The Eggborough CCGT Project

Document Ref: 2.5 PINS Ref: EN010081

Explanatory Note on Changes to Draft DCO - Deadline 2

Date: November 2017

Drawing Title  
**INDICATIVE COFFERDAM ARRANGEMENT  
 (COOLER WATER DISCHARGE POINT)**

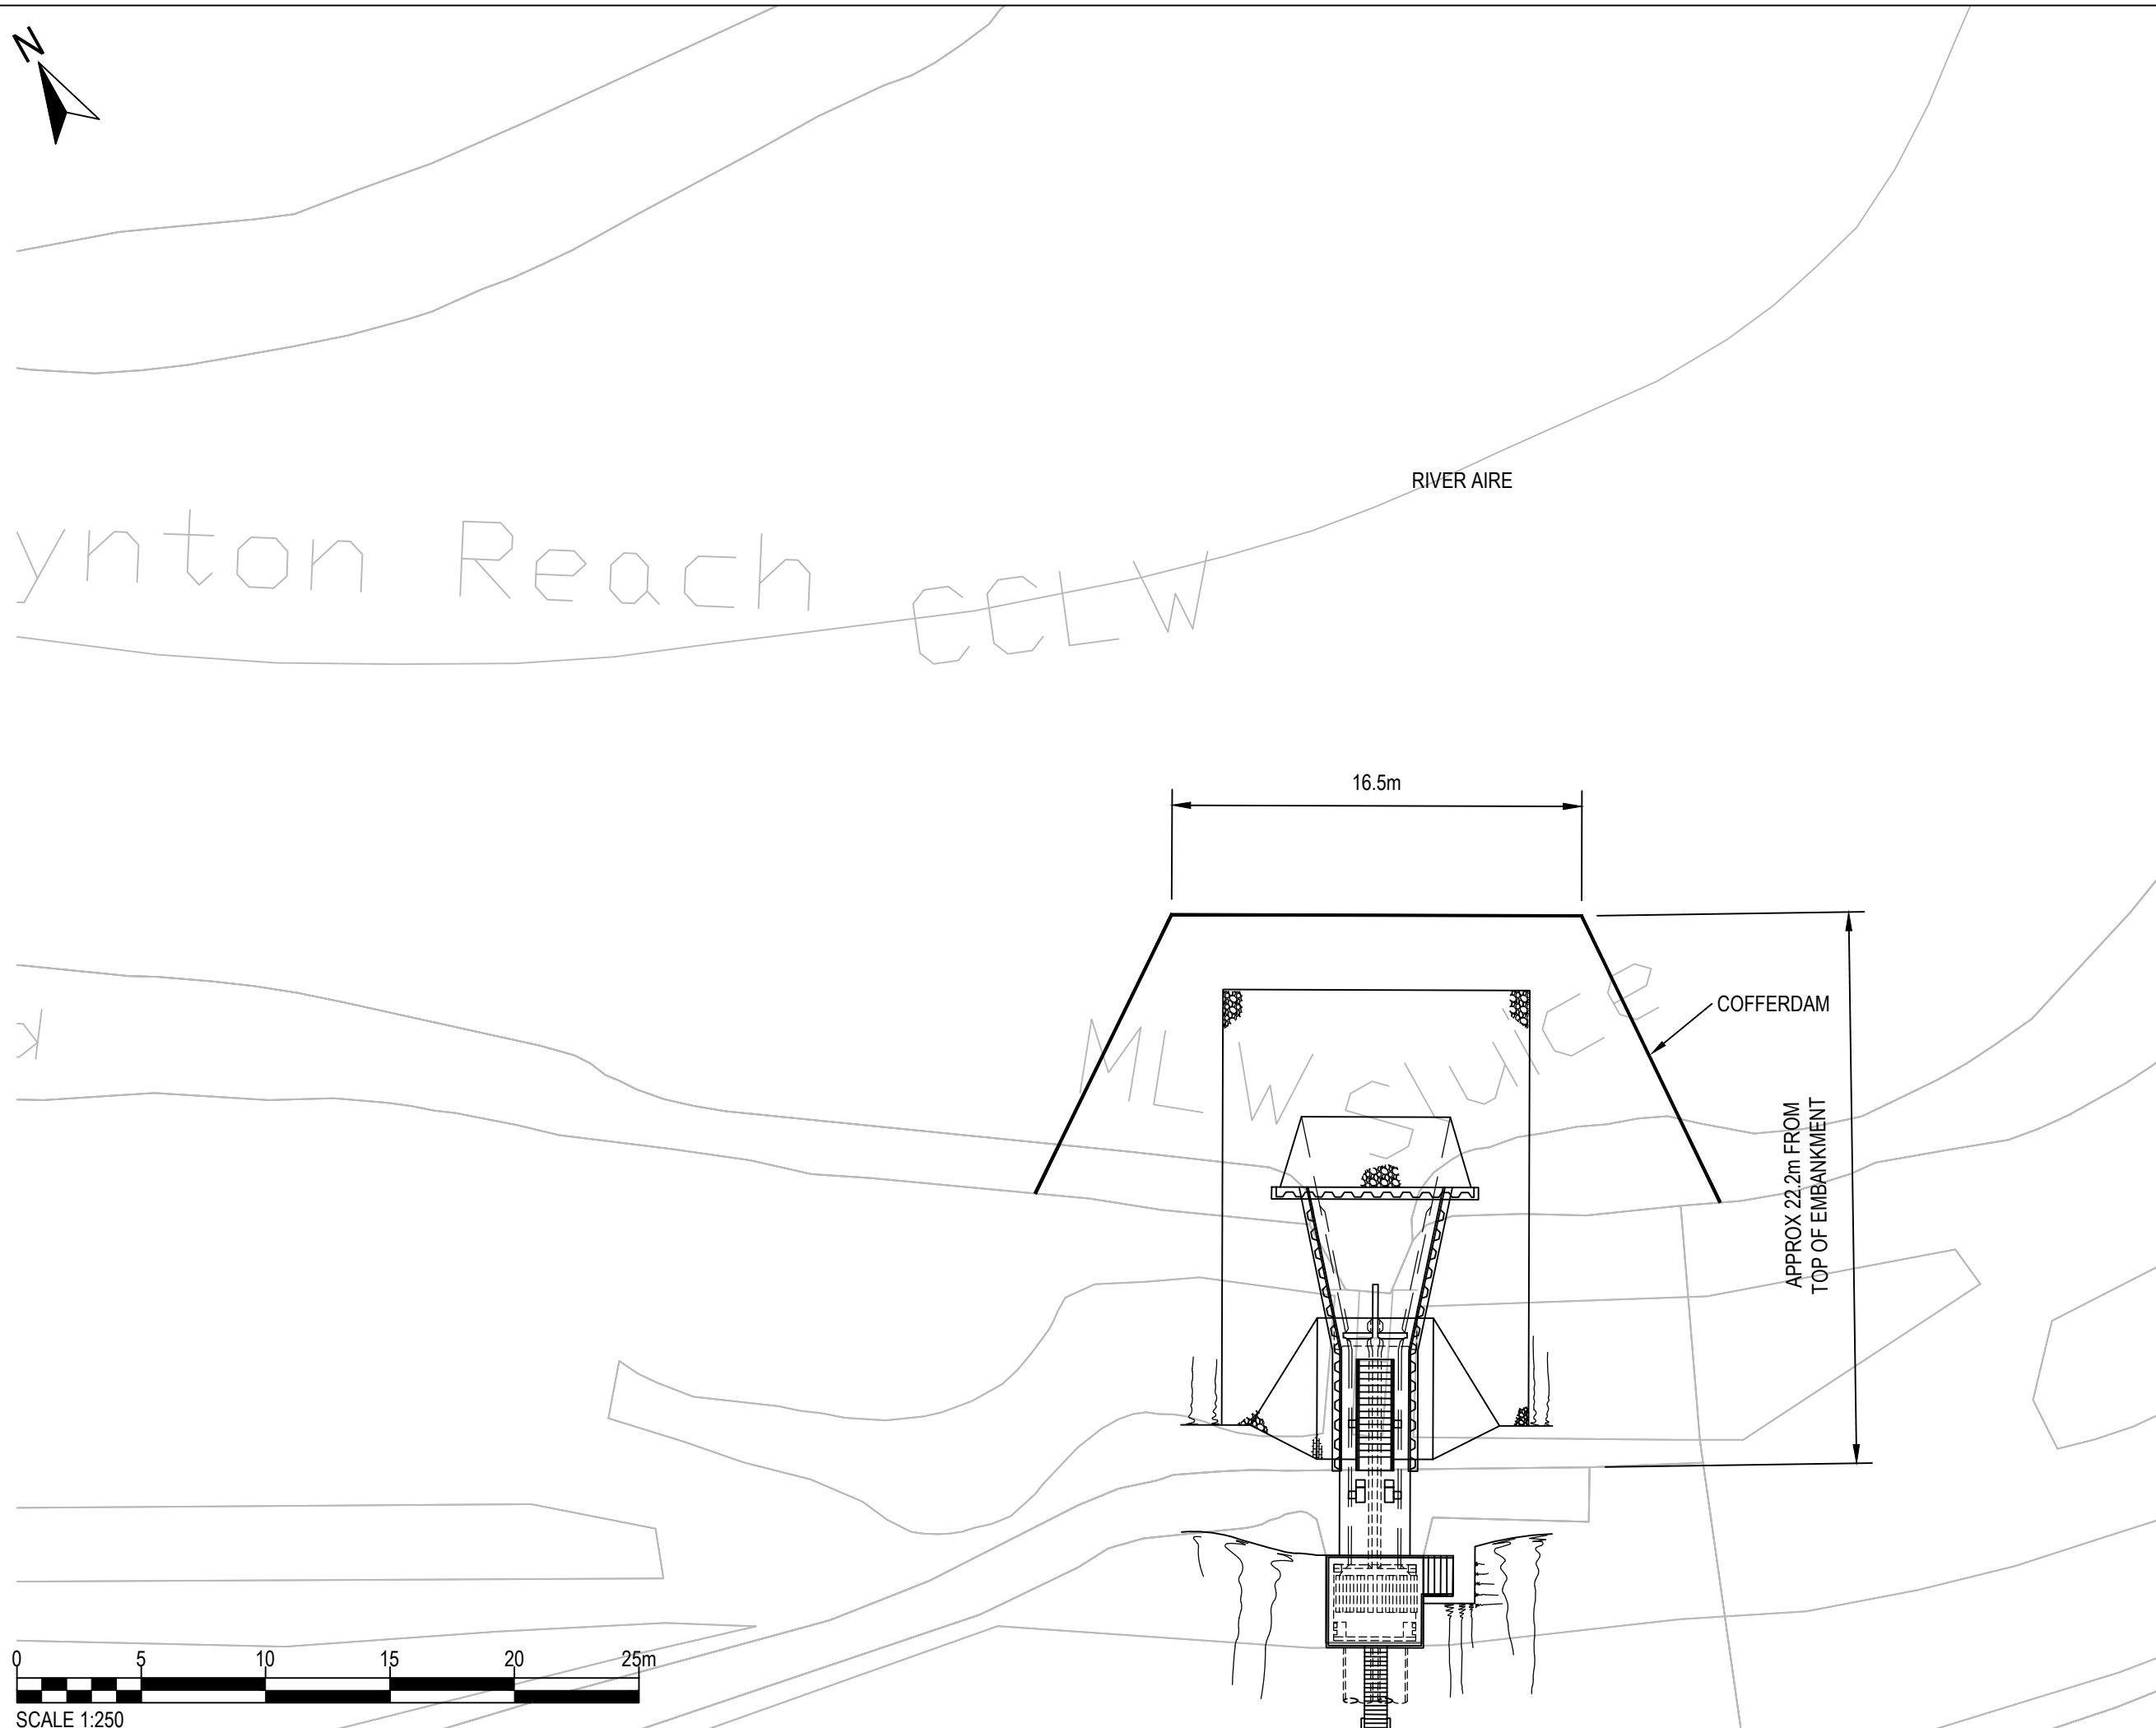
• Sub-paragraph (5)(c) has been amended to include details of the method and timing of the installation and removal of the cofferdams at the intake and outfall. Please refer to FWQ FW 1.11.
